DECISION DELEGATED TO HEAD OF PLANNING

Application No: H16-0799-26 **Applicant:** Mr Barrett
Proposal: Change of use from C4 House in Multiple Occupation to a Sui Generis large House in Multiple Occupation for up to 7-persons
Location: 3 Green Lane Spalding
Terminal Date: 20th October 2026

Drawing:
Proposed Floor Plans

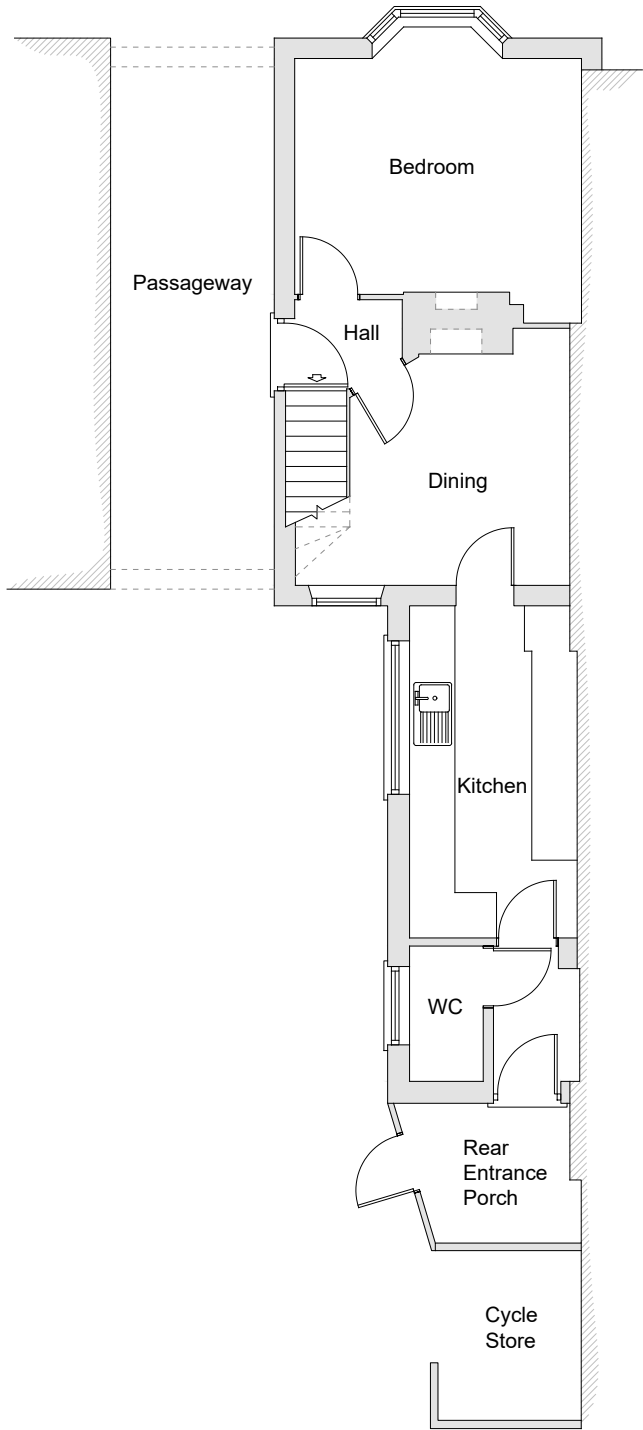
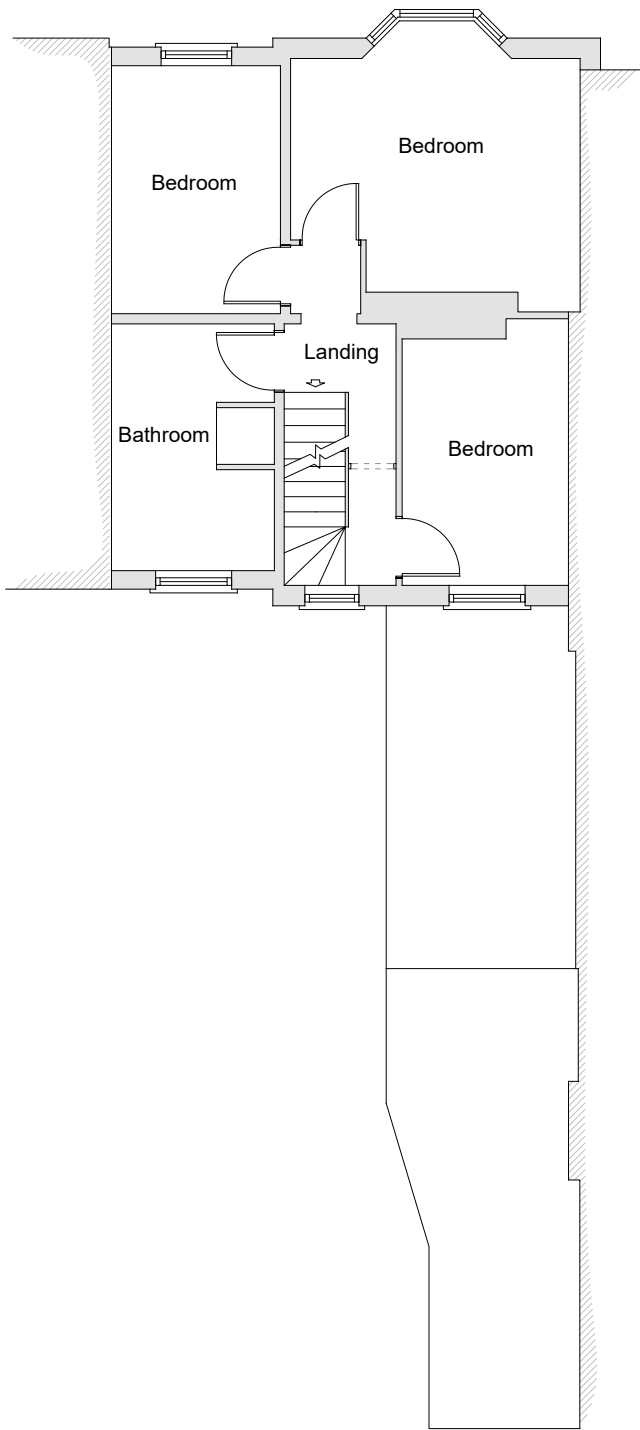
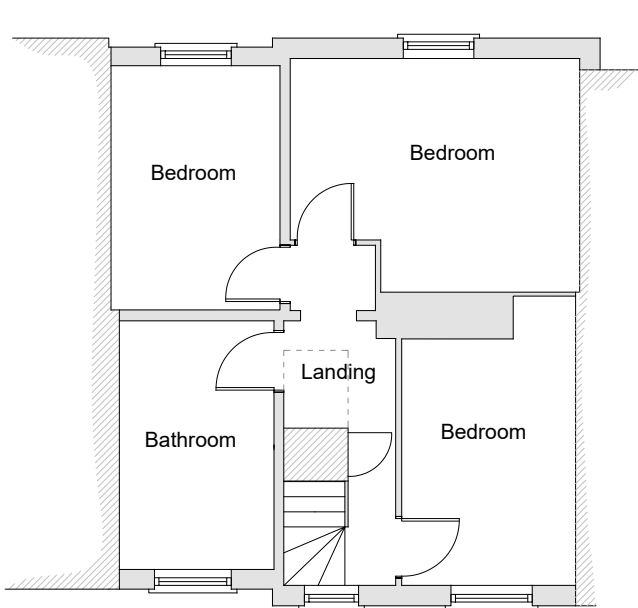
- Ground floor - dining room, kitchen, WC, cycle store (external), porch and bedroom 1 (12.6sqm)
- First floor (clockwise starting with the top right) - bedroom 2 (12.15sqm), bedroom 3 (7.32sqm), bathroom, bedroom 4 (7.29sqm).
- Second floor - bedroom 5 (11sqm), bedroom 6 (8sqm), bathroom, bedroom 7 (7.2sqm)

7.The proposal is considered to fail criterion 7. The Nationally Described Space Standards, which Policy 21 expressly requires the use of, require a minimum floor area of 7.5sqm for a bedroom. Three bedrooms are below this figure. Given the lack of shared living space available, occupants would be forced to spend a disproportionate time in their own rooms, which due to their size would be uncondusive to a good standard of residential amenity.

Moreover, the approximate total floor area of the property is 130sqm. Whilst the Space Standards do not extend to a 7 bedroom property, the formula can be extrapolated to give a floor space of 142sqm for a three-storey, seven bedroom property. The proposal would therefore fail to meet space standards.

8.The proposal is considered to fail criterion 8. Whilst a small garden is present, the only shared internal space, beyond the kitchen and bathrooms, is a small dining room. No shared living room or comparable feature is present. Given the number of occupants, this is considered to be entirely insufficient for their needs, and below the requirements expected under criterion 8. It should also be noted that the shared kitchen is relatively small given the number of occupants.

As outlined within the assessment under Policy 21 of the SELLP, whilst the proposal would not have a harmful impact upon amenity of neighbouring properties, it would fail to provide a suitable standard of residential amenity. No shared internal amenity space is provided bar the dining room. There is a small external amenity area, although the practicality of this element, and whether it is large enough to serve the number of occupants proposed, particularly given the lack of internal space, has not been demonstrated. Given the provisions of Policy 21, which is explicit that shared amenity space should be provided, it is not considered that adequate amenity space has been provided.

Moreover, as discussed earlier in this report, several rooms do not meet the requirements of the Nationally Described Space Standards. Policy 21 is explicit that these requirements should be met, and therefore, there is conflict with this Policy resulting from this. Given the absence of shared amenity space, it is considered that the effect of these overly small rooms would be more greatly felt. The lack of shared amenity space would result in residents spending more time within their rooms. Therefore, these rooms being undersized would result in an environment conducive to proper living standards.

Existing Floor Plans

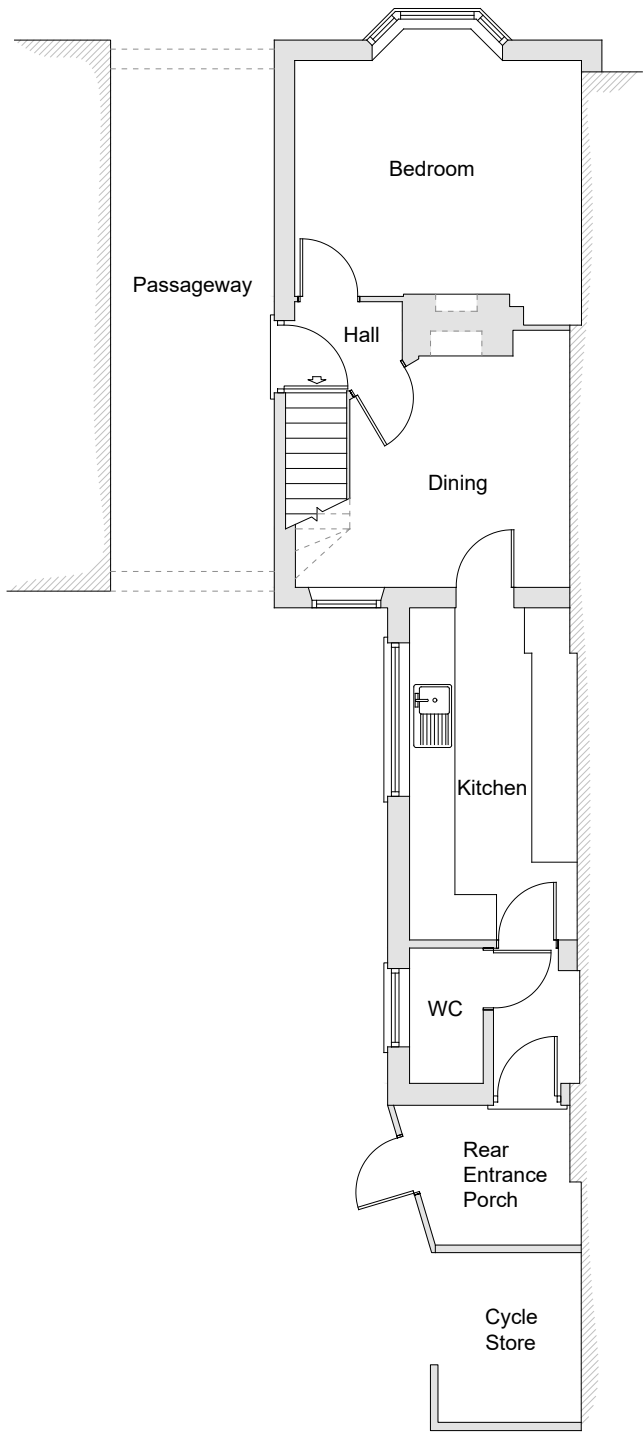
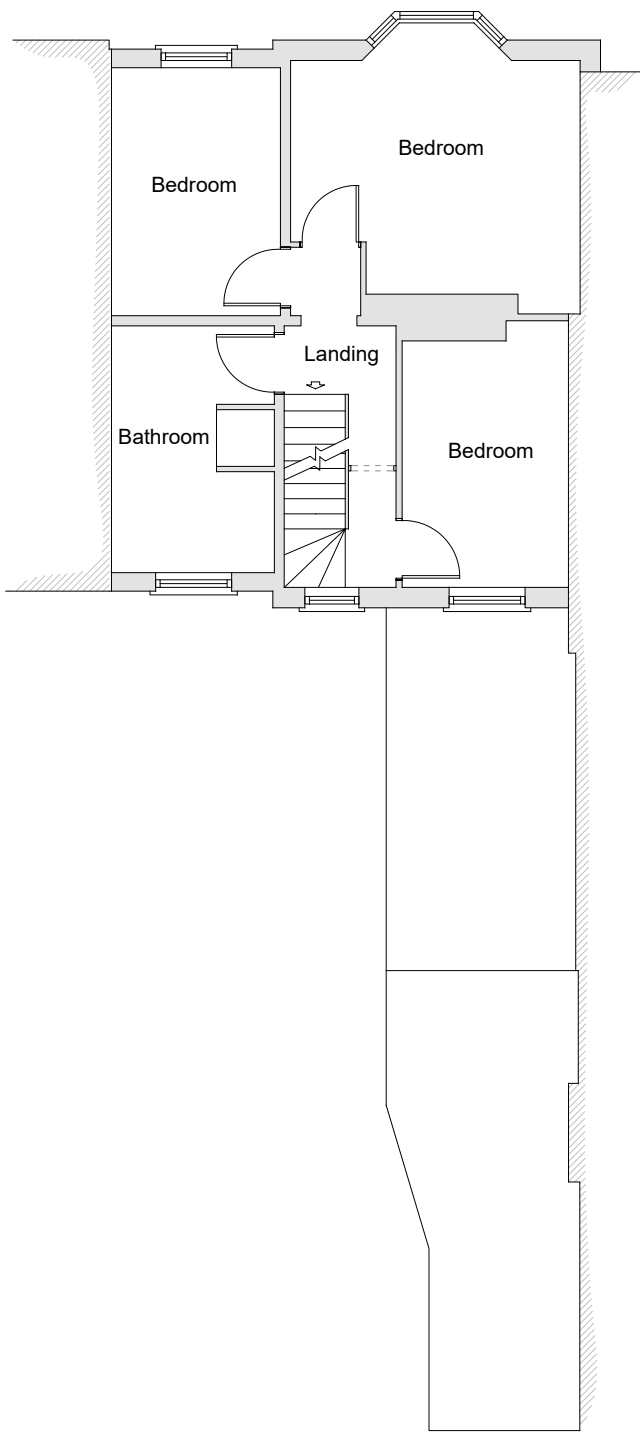
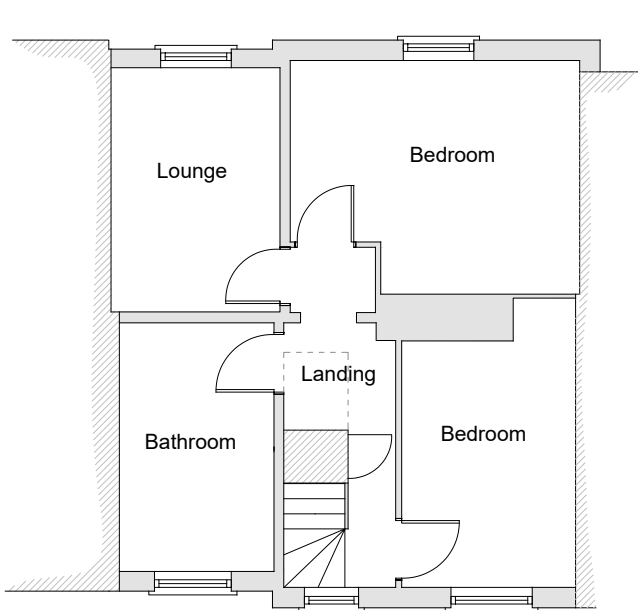
The alternative fallback of a six bedroom HMO, which would be permissible under the provisions of the General Permitted Development Order is noted with regards to the above assessment. However, the floor plan provided shows a communal living room within this alternative arrangement. There would also be reduced pressures placed upon the kitchen space and external spaces.

Therefore, the level of accommodation and amenity space offered for a six bedroom scheme would be far greater than that proposed here. As such, whilst this fallback is acknowledged, the circumstances are materially different here.
